Our ref: OUT24/14373

Subject: Wallgrove Business Hub (SSD-50972718)– Environmental Impact Statement (EIS)

Detailed advice to DPHI Planning & Assessment regarding the Wallgrove Business Hub (SSD-50972718)- EIS

Figure 4: Bulk Earthworks Cutting and Filling Plan – Stage One. Henry & Hymas 2025

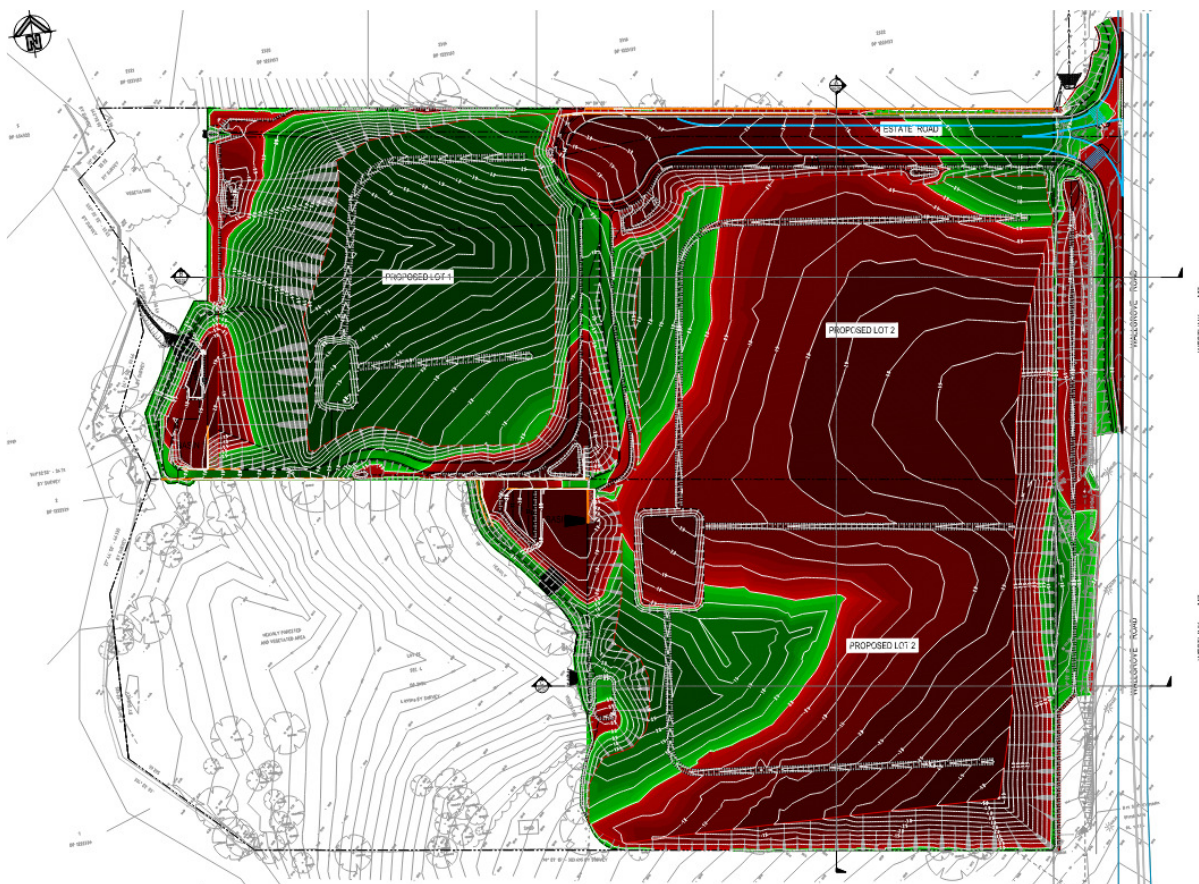
Insufficient information has been provided to confirm the potential groundwater inflow volumes. The proponent provides groundwater level data between 1.34m and 4.7m below ground level in some locations with excavation reaching between 4m and 6m below ground level indicated by the earthworks plans. Quantification of maximum potential inflow volumes is required.
